From: Martyn White
Sent: 15 May 2018 16:35
To: Andrew Wood
Subject: AW 45 18 HH

The conservation area has developed incrementally over a 70 (or so) year period, and as a result, there is a strong mix of styles and agers of properties. The property in question appears to reflect some traditional characteristics through the use of what appears to be 'clay tiles' and orange/red brick. The proposal suggests using replacement bricks and tiles which will potentially reduce the dominance of the property. This has the potential benefit of helping to reduce the impact of the proposed works.

sheet 3 of 5

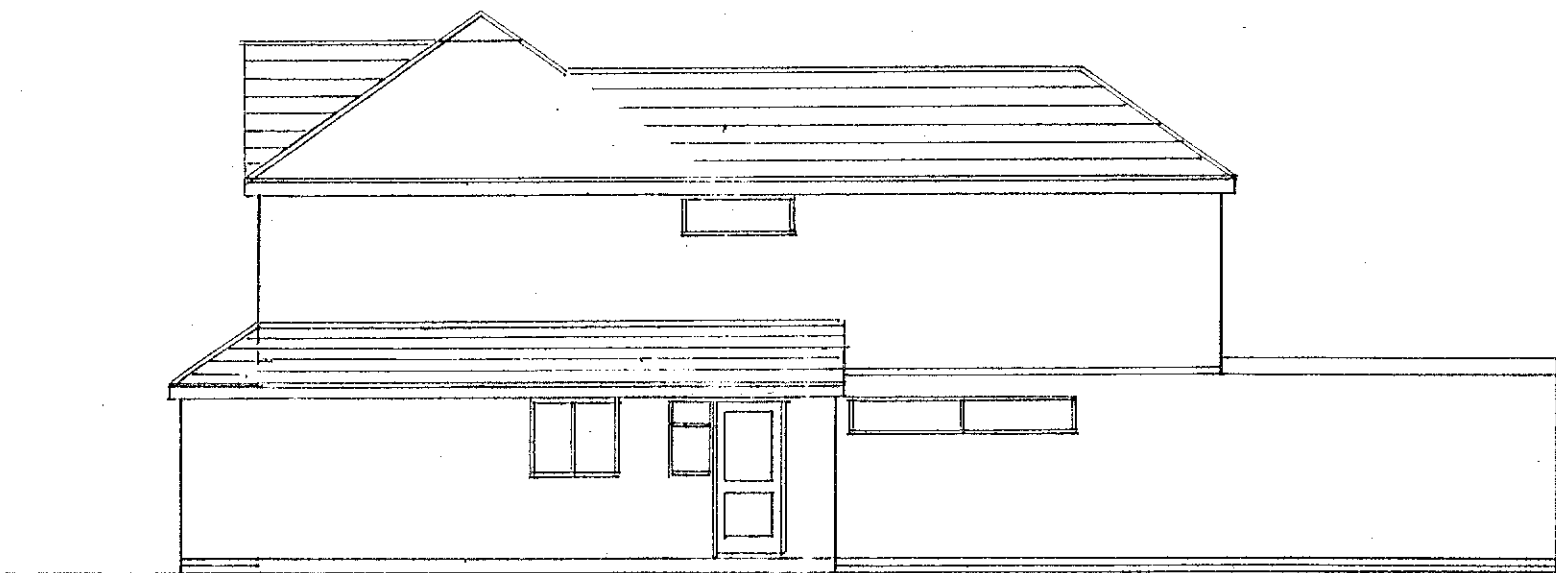
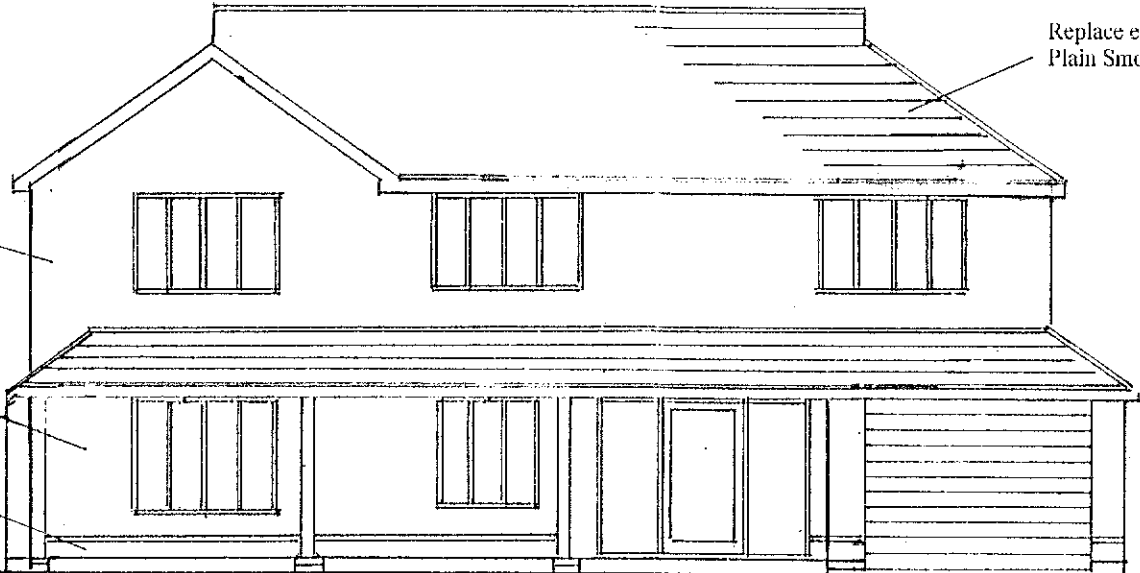
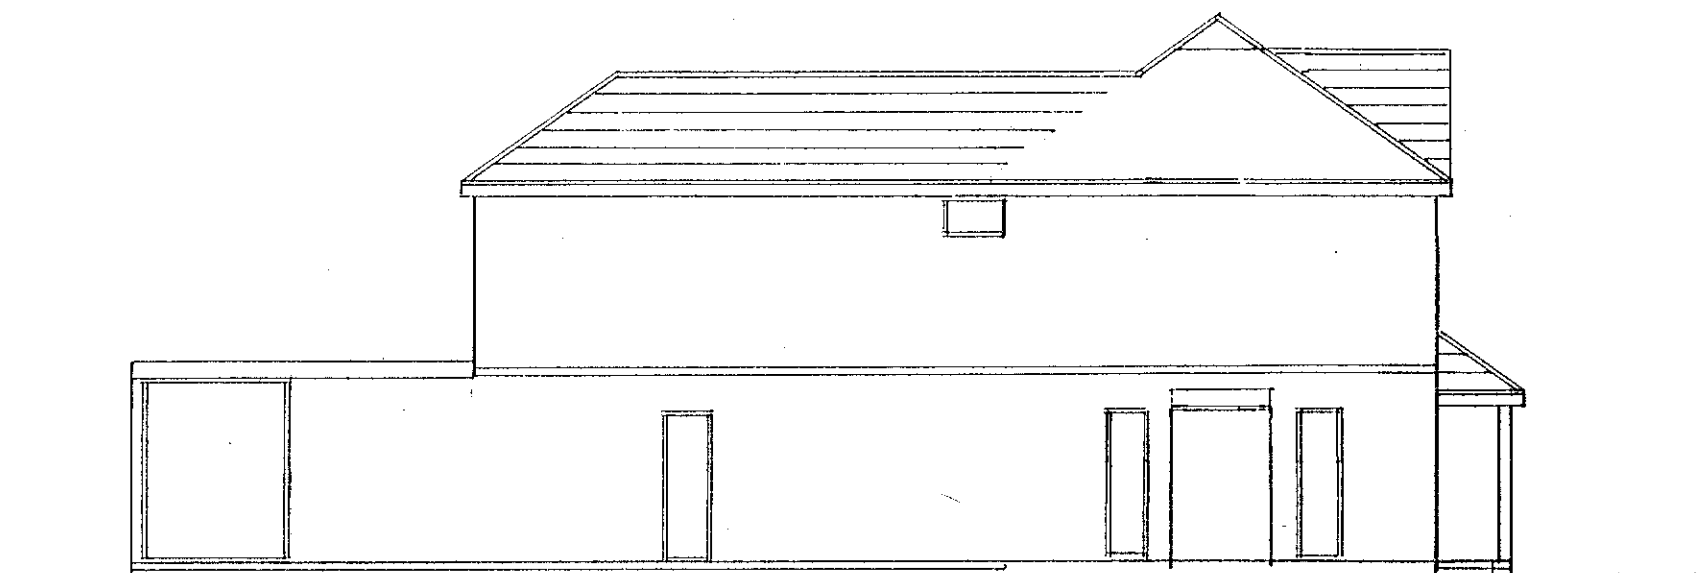
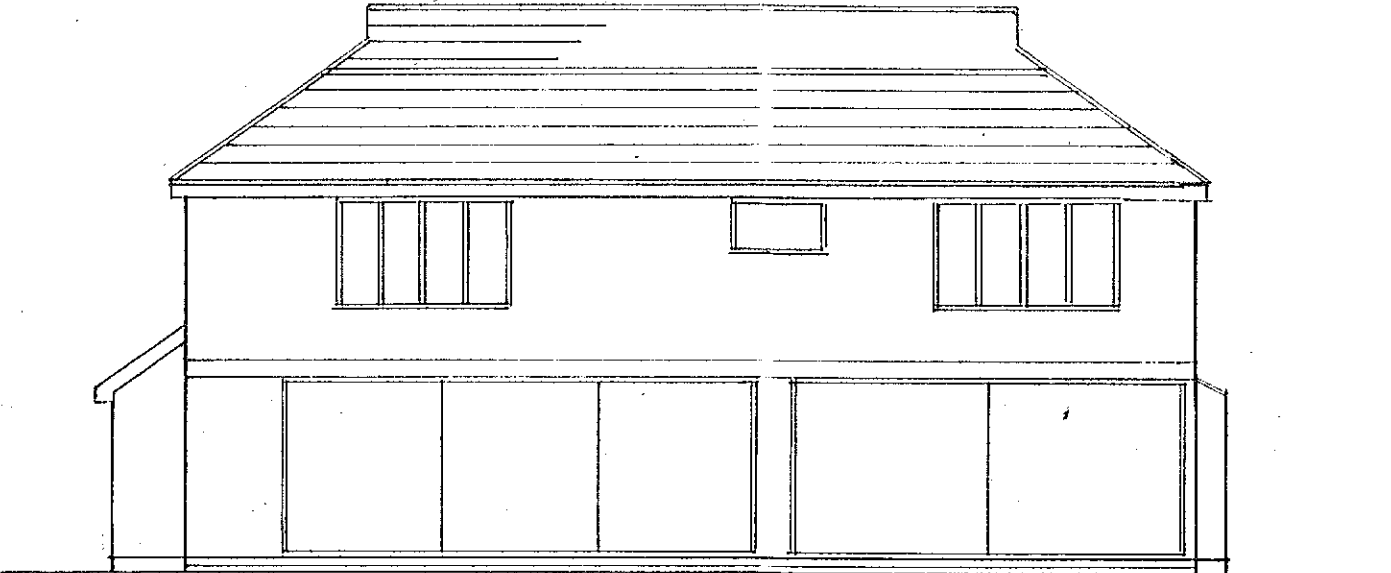
The proposed development forms a substantial extension to the existing property and will transform it. The previous Conservation Officer provided comments related to the veranda on the front elevation. The revised plans appear to result in the removal of the majority of this from the proposals, leaving one small section. As now drawn it is considered that the proposals seem to comply with this part of her comments – this leaves some feature on the front elevation.

However, the works are still substantial in nature and will somewhat subsume the host dwelling (and existing garage structure). As a consequence, the impact on the neighbouring Locally Listed dwelling and the Conservation Area needs to be considered. The works to the rear of the property will have limited impact upon the Conservation Area. However, the works to the front will have a greater impact (the entire of the front elevation will change in appearance); the use of render at the ground floor level forms the introduction of a new material to the property. It is assumed that this is related to the relocation of the ground floor windows. Render is a material found throughout

If minded to approve the application, the success of such a scheme will depend upon the quality of the materials used and the colours chosen. There does not appear to be any information related to the windows, or the colours so you may wish to condition these. Details of these will be required to ensure that some of the traditional characteristics of the existing (and neighbouring) property remain.
